Recommendation Report for Planning Permission for Works or Extension to a Dwelling

REF NO: Y/53/25/HH

LOCATION: Flints
Hoe Lane
Flansham
PO22 8NP

PROPOSAL: Part single, part two storey rear extension, dormer extension and alterations to fenestration.

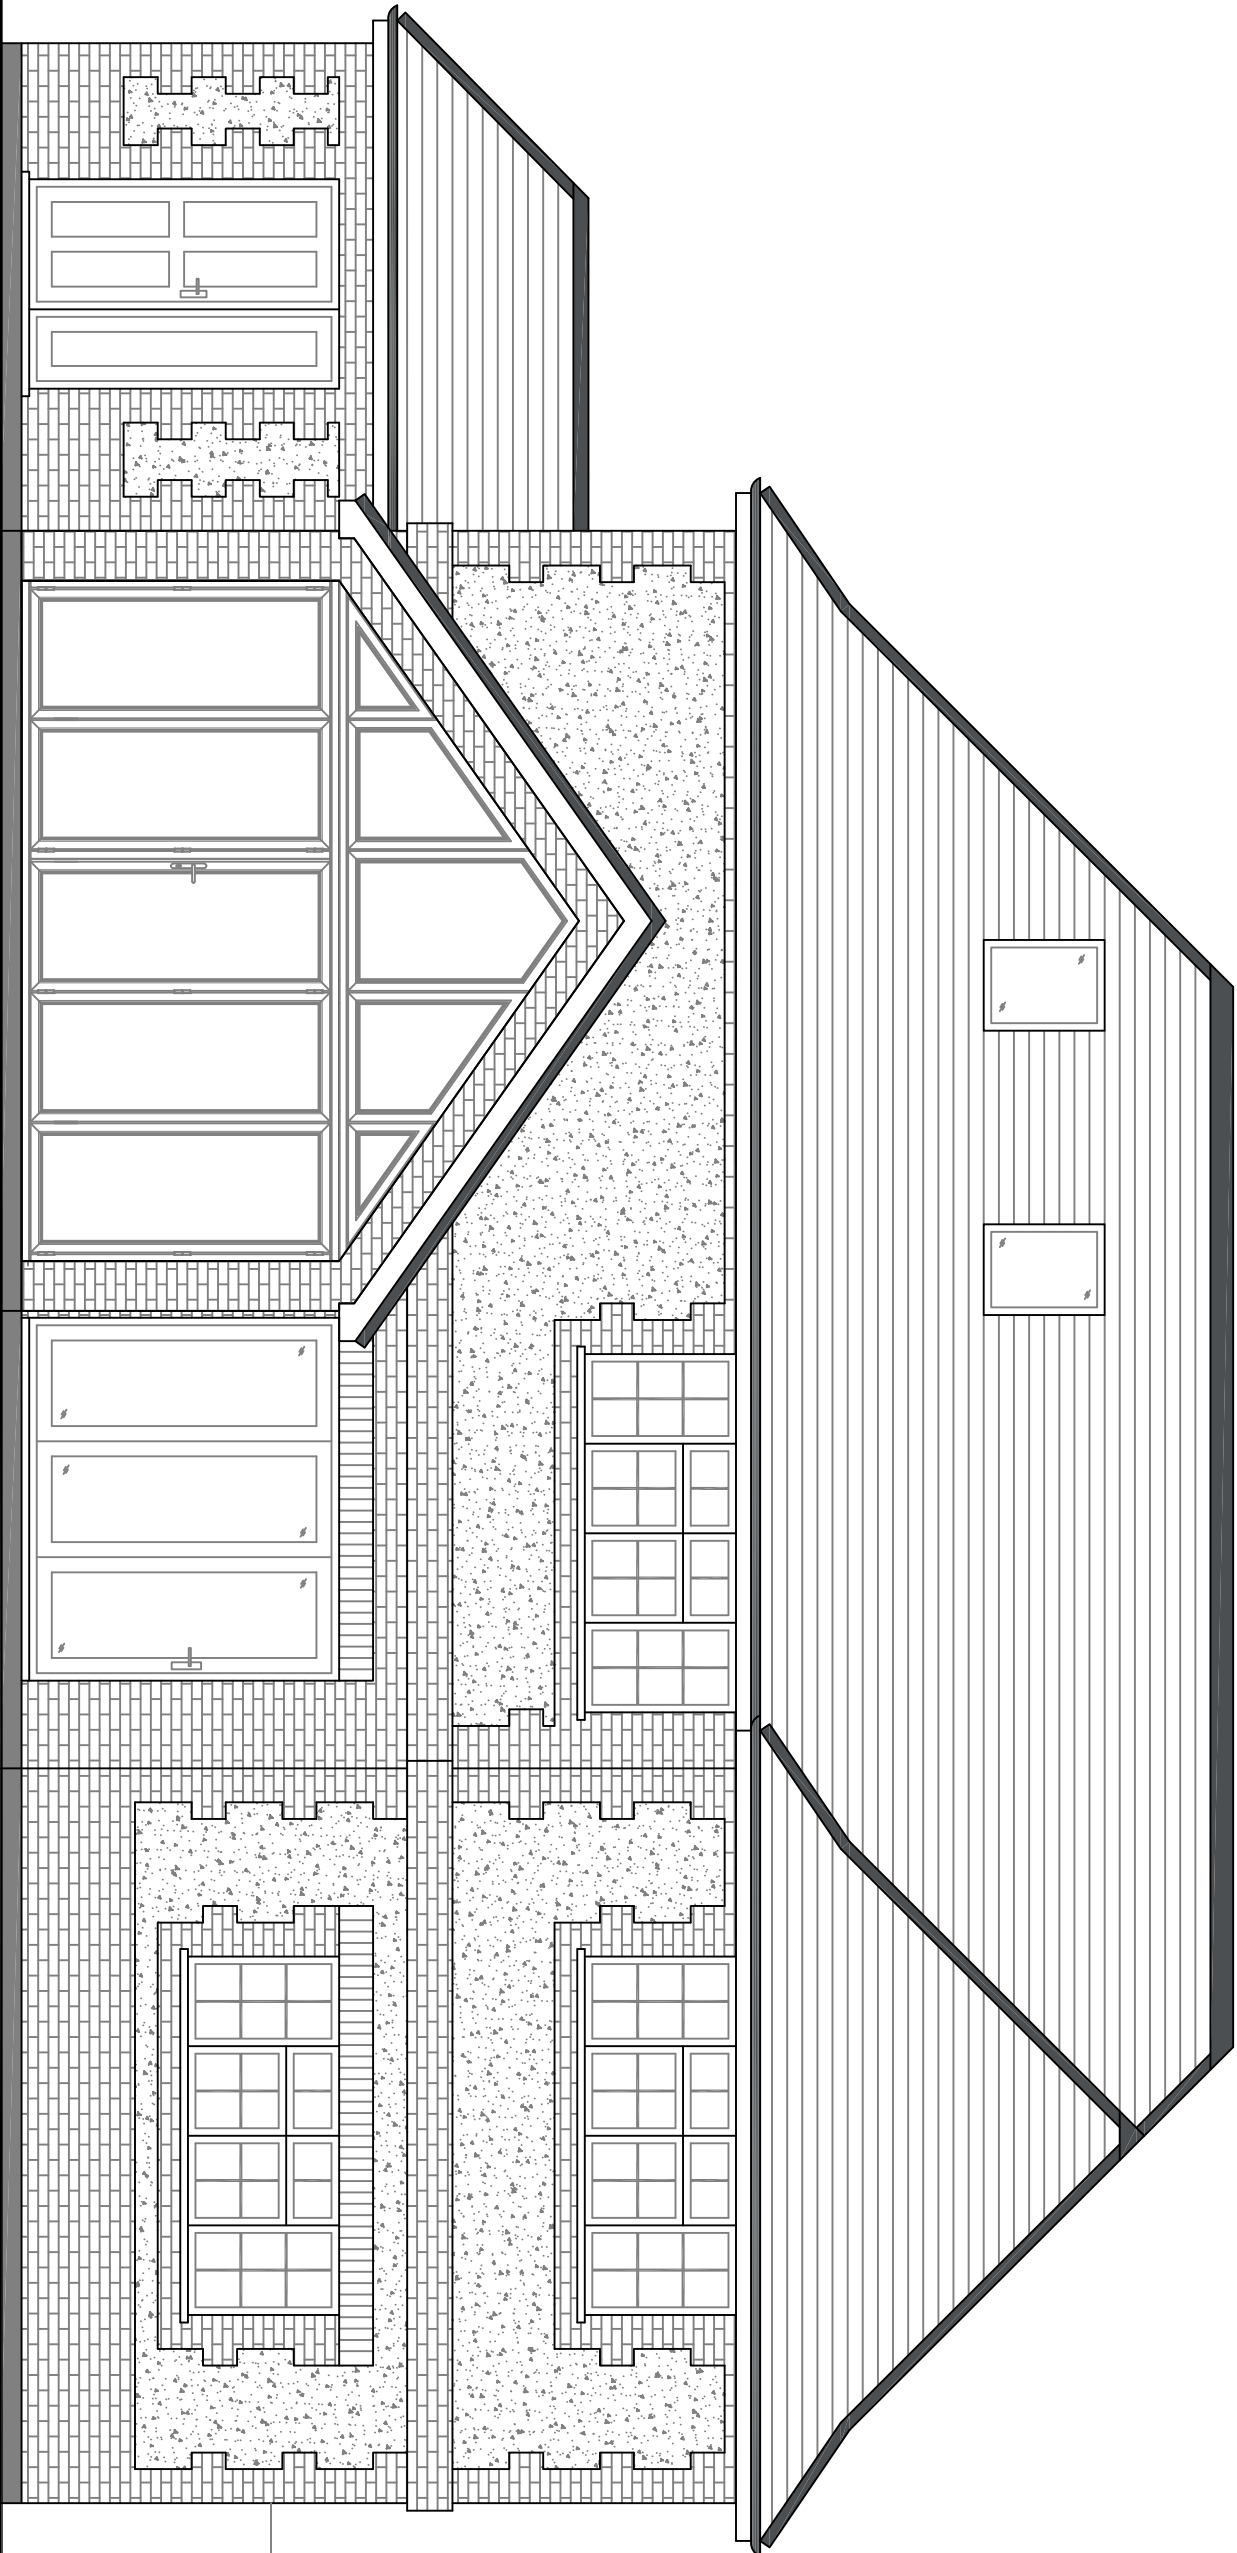
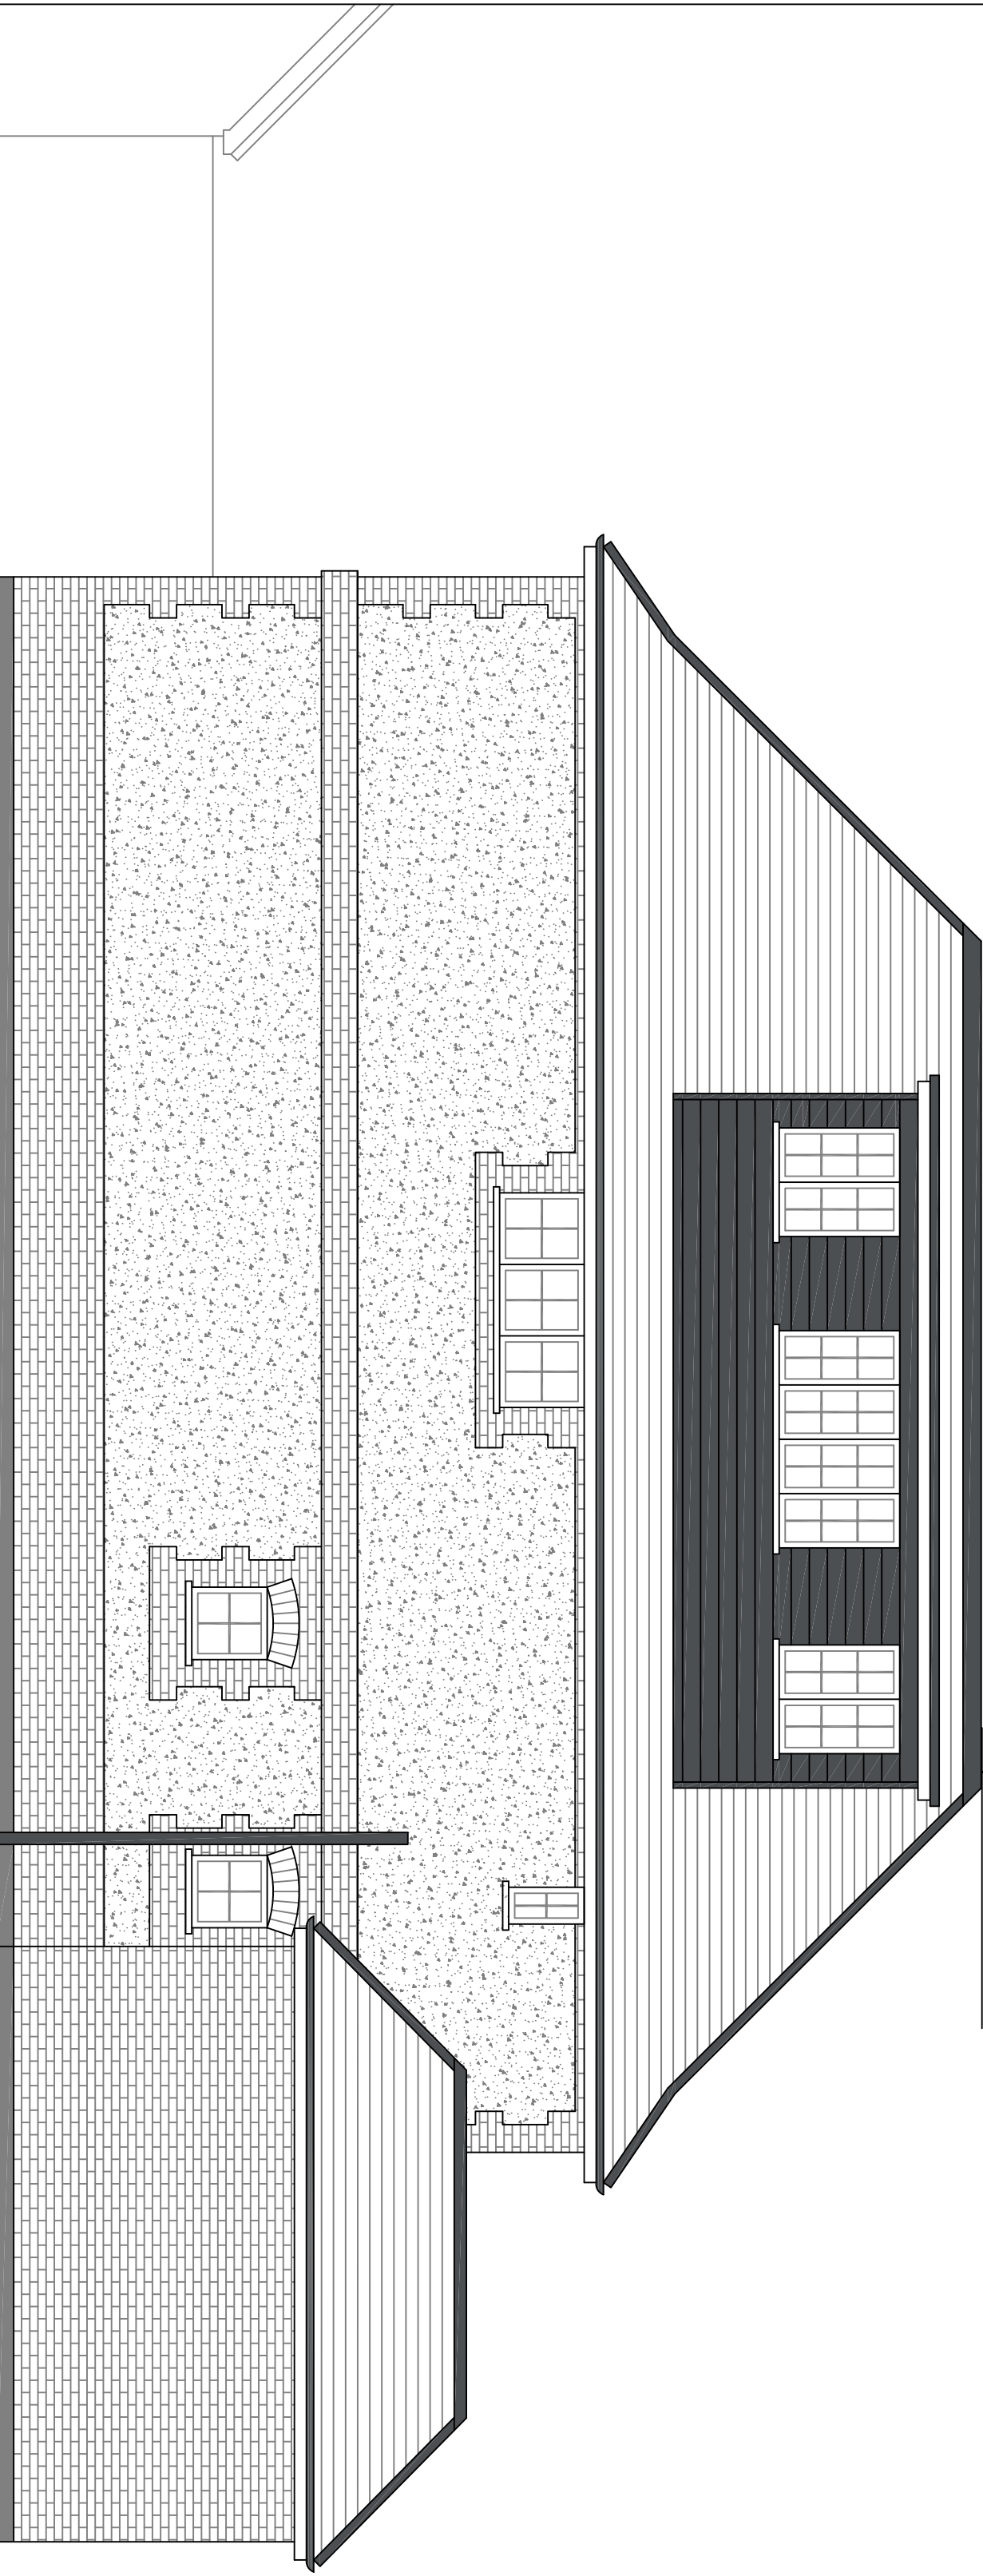
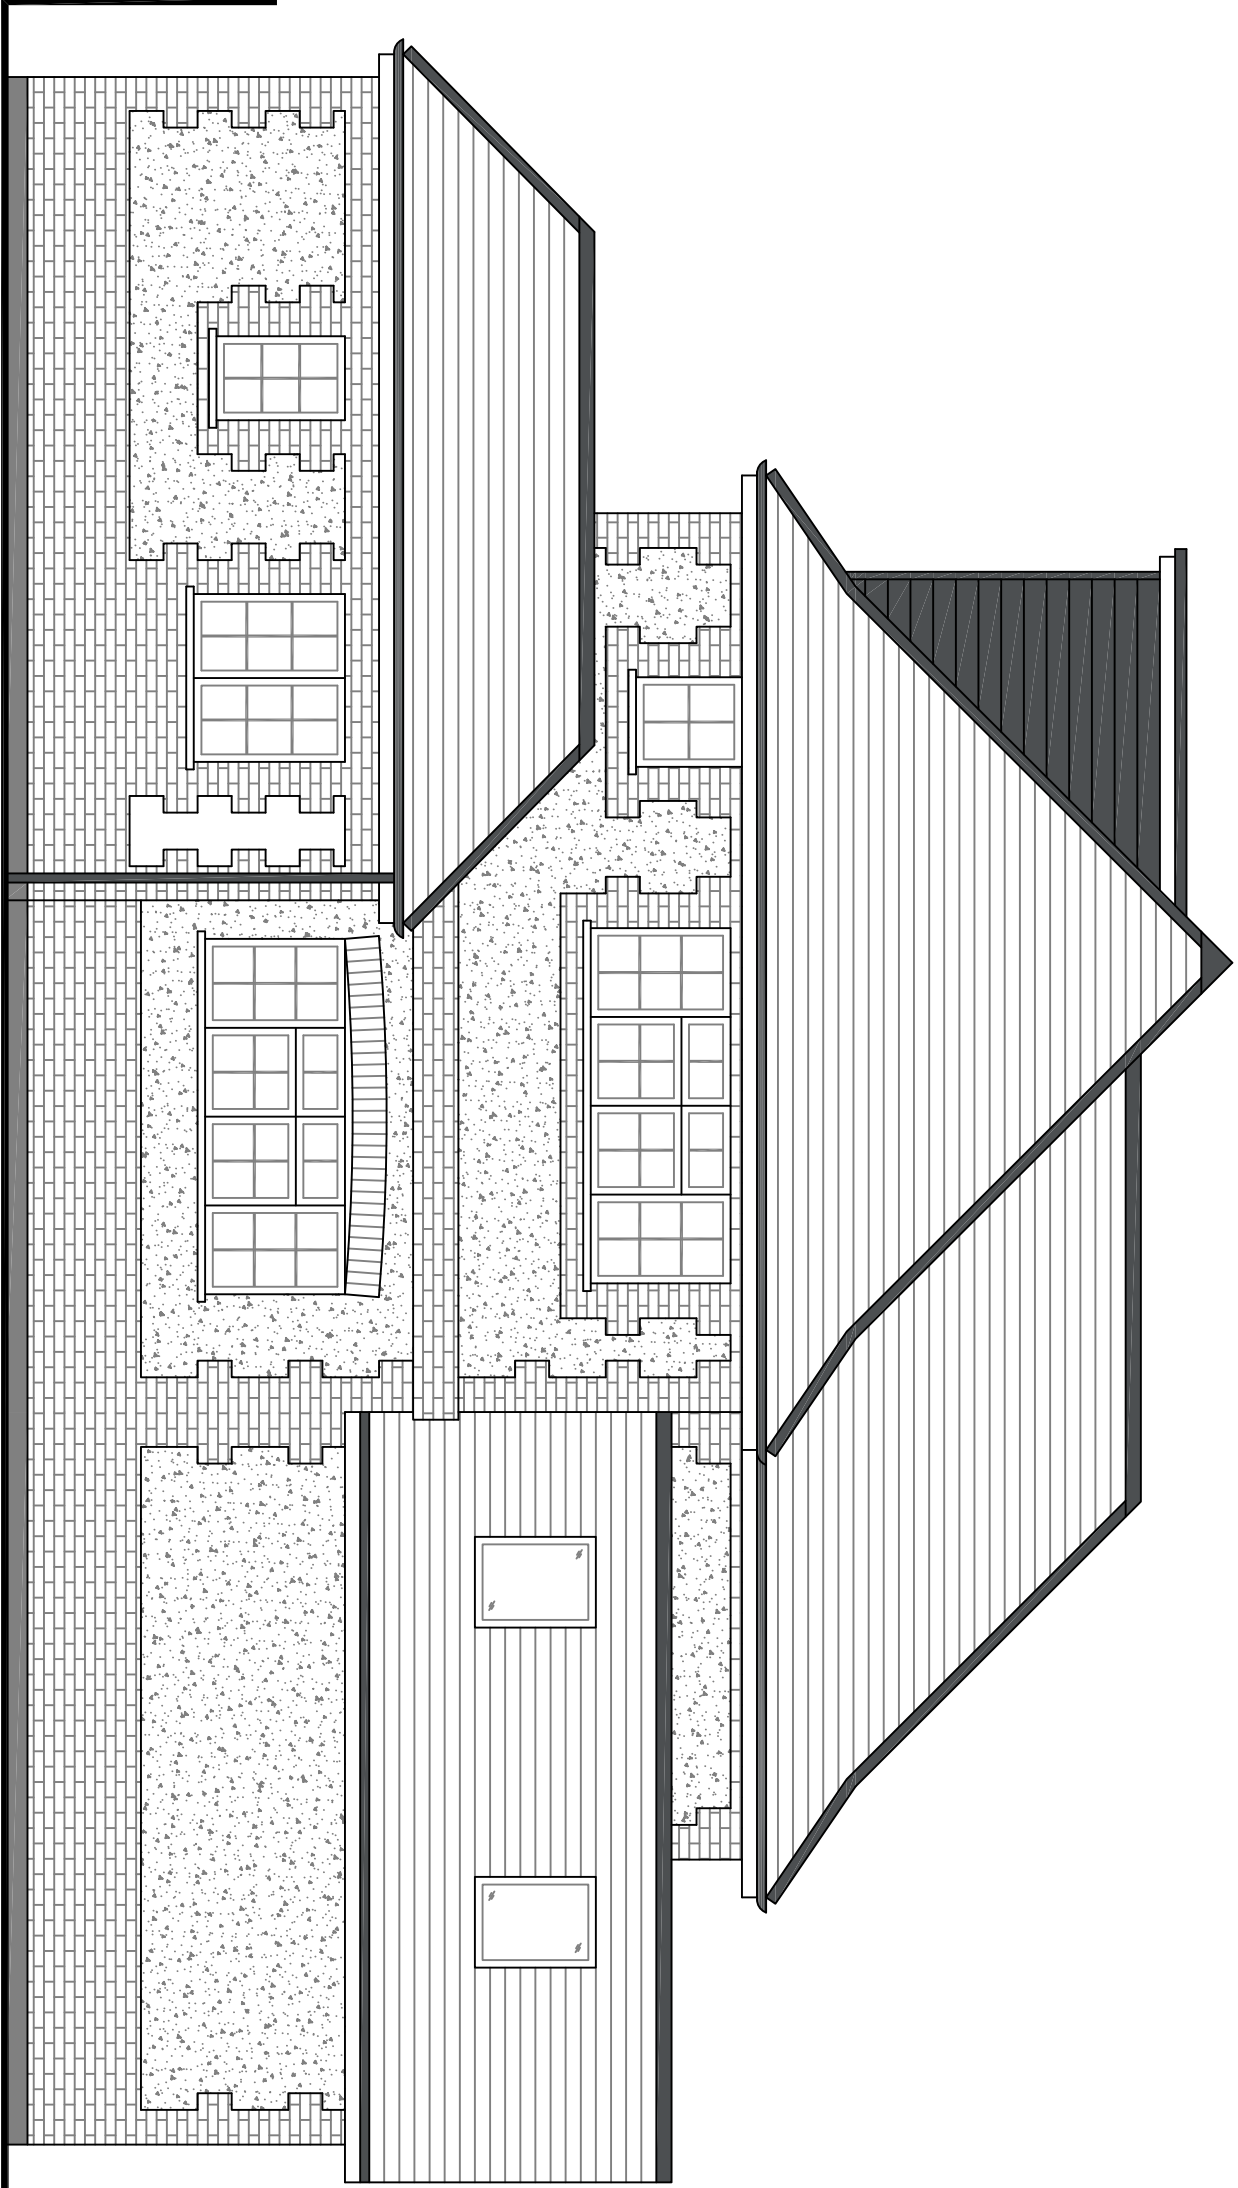
The proposed single storey extension would measure 5m in width, 4.7m in depth, with a maximum height of 4.4m and eaves height of 2.3m. It would feature a gable end with large windows. Whilst this extension would have a more modern appearance than the host dwelling, it is subservient and would not appear prominent within the street scene of Hoe Lane, reducing any harm to the character of the area.

The first floor extension would measure 4.7m in width, 3m in depth and would match the eaves height of the host dwelling. The first floor extension would increase the bulk and massing of the roof form, although it would not exceed the existing ridge height. The first floor extension would replace an existing catslide roof form, however the hipped roof form of the first floor extension would reflect the character and appearance of the host dwelling and the proposal would be of a size and scale that would be a subservient addition to the host dwelling. The proposed first floor extension would not result in harm to the visual amenity of the host dwelling, street scene or wider area.

The rear dormer would measure 5.7m in width and 2.1m in depth, with a flat roof with a height of 2.2m. There is an existing smaller dormer which the proposed would replace in a similar location on the west (rear) roof slope. Part M of the Arun Design Guide (ADG) requires dormers to be minor incidents in the roof plane and centrally located as to not damage the original character and appearance of the building and its surrounding area, incorporating pitched roof in most cases. While the proposed rear dormer features a flat roof design, it is sited to the rear and would not be visible from the street scene. The dormer would be set in from the flank elevations, set up from the eaves and set down from the ridge height and would not result in harm to the visual amenity of the host dwelling.

The single storey extension is sited approximately 13m from the boundary with the north (side) neighbour, Bonhams. There are large scale windows proposed to the east and north elevations, but as these windows would have an outlook of the rear garden, the proposed extension would not result in increased overlooking impacts. As a result of its scale and siting, this element would not result in any overbearing, overshadowing, or overlooking, and would not result in harm to residential amenity. 2 No. rooflights are proposed within the south (side) roof slope. There are 3 No. existing rooflights within the main roof. The rooflights accord with Part M of the Arun Design Guide as they maintain the privacy of the neighbouring properties and are used discreetly.

The first floor extension would be sited approximately 6m from the boundary with the north (side) neighbour, Bonhams. Given the siting and scale of the proposed extension, this element would not result in any overshadowing or overbearing impacts to neighbouring properties. Fenestration is proposed within the eastern elevation of the extension at ground and first floor levels. The outlook from this fenestration would not be dissimilar to the views available from the existing ground and first floor level fenestration within the eastern elevation, and the proposal would not result in additional overlooking or loss of privacy.

The rear dormer would be sited approximately 35m from the closest elevation of the neighbour to the rear, Jem House, and would not result in harmful overlooking impacts due to this distance and the existing boundary treatment and mature vegetative screening. As the dormer would be contained within the existing roof slope and would be sited a significant distance from neighbouring properties, the dormer would not result in any overbearing or overshadowing impacts.

There are proposed alterations to fenestration including a set of patio doors within the north elevation, serving the rear garden of the host dwelling. 1 No. window is removed from the south elevation and 2 No. windows are introduced within the east elevation. Both would serve the rear garden and would not result in increased overlooking impacts.
